Dr Mary Clare Martin on behalf of Mrs Joy Thompson, landowner of Low Broomrigg.

**Post-hearing submission following the accompanied site inspection (28<sup>th</sup> February), the Compulsory Acquisition Hearing 2 and the Issue Specific Hearing 3.**

Drawing Title: Classification of Roads Plan Regulation 5(2)(o) Sheet 1 of 2

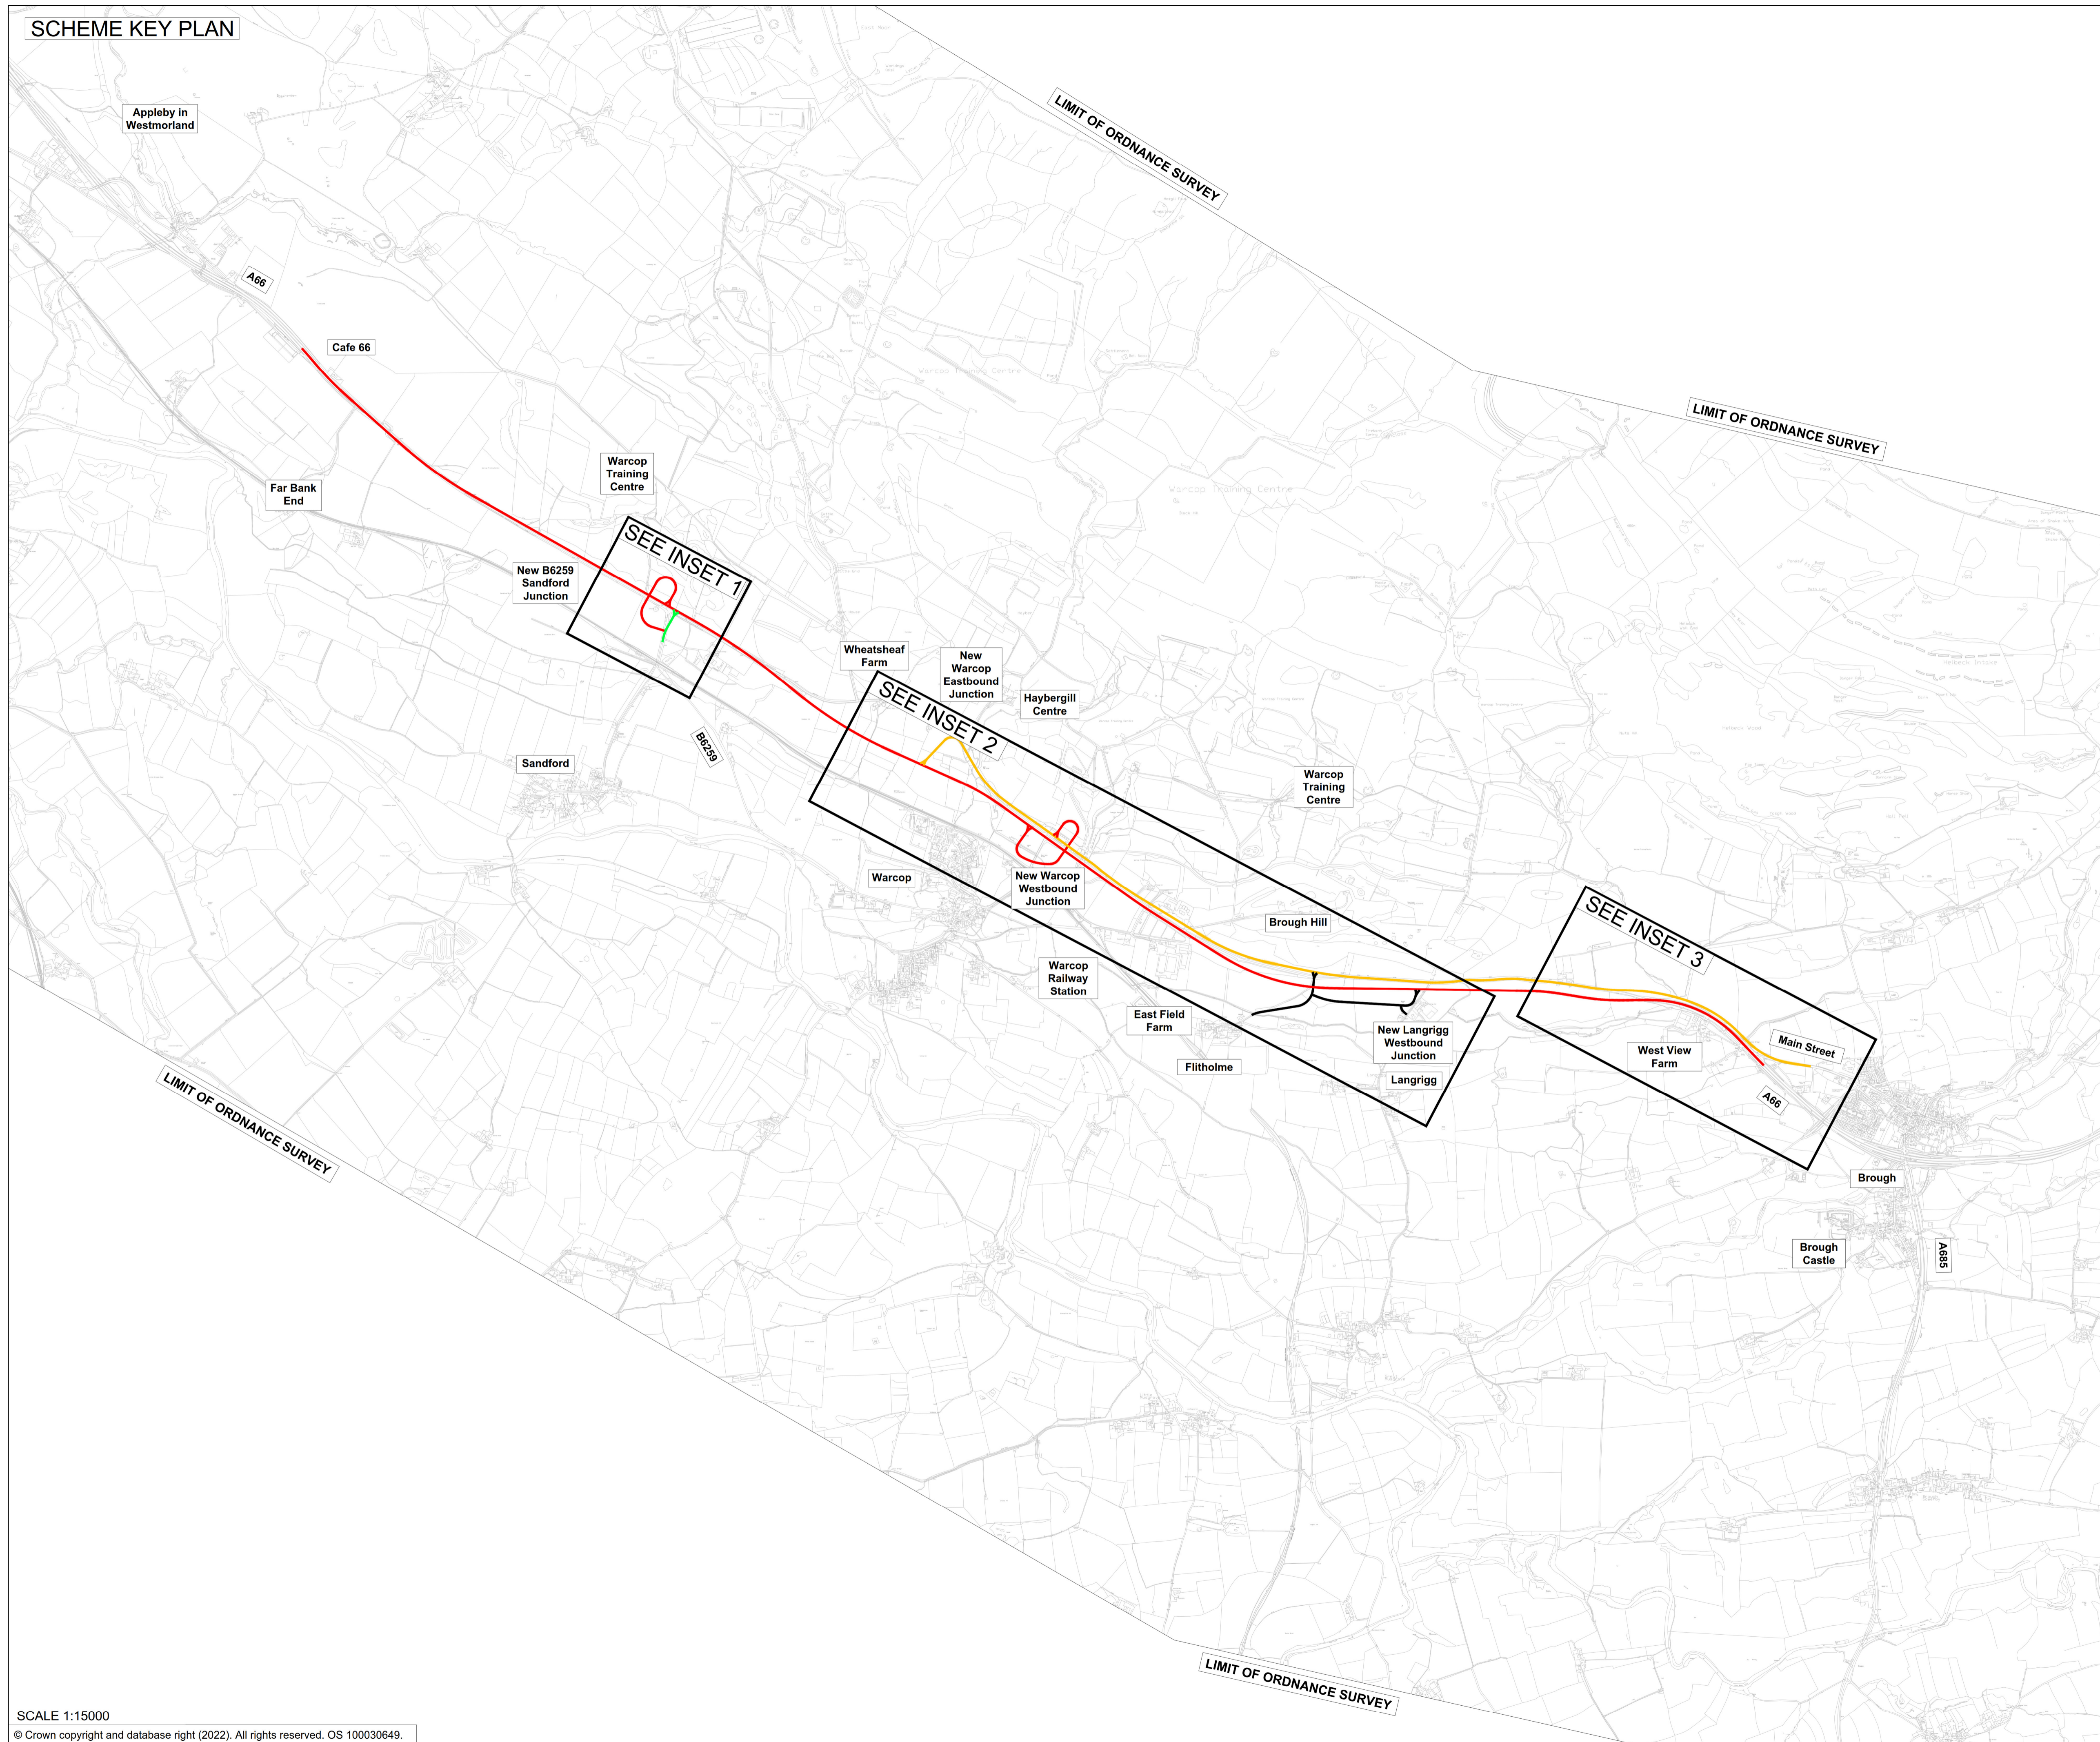
At the accompanied site inspection, we pointed out that the noise levels on the current A66 are far greater than near the house. Building a new dual carriageway and access road closer to the house will clearly impact significantly on noise and air pollution, make life very difficult [REDACTED], as well as impacting on the landscape.

At CAH2 I reiterated that the DCO designs for the Langrigg Junction comprise an infringement of human rights legislation on grounds of age and disability. The ExA noted that there were a number of relevant issues.

The barrister for National Highways indicated that the proposed change to the Langrigg Junction would be an improvement for the residents of Low Broomrigg, and that everyone wanted to see this issue resolved. However, we do not yet know the results of the new non-statutory consultation, nor whether the proposed changes will be accepted by the ExA. Moreover, moving the dual carriageway further from the house, although an improvement, will not remove the harm done by living near construction works, and close to additional roads, particularly for old and disabled people. The roads will also have a detrimental effect on the value of the property.
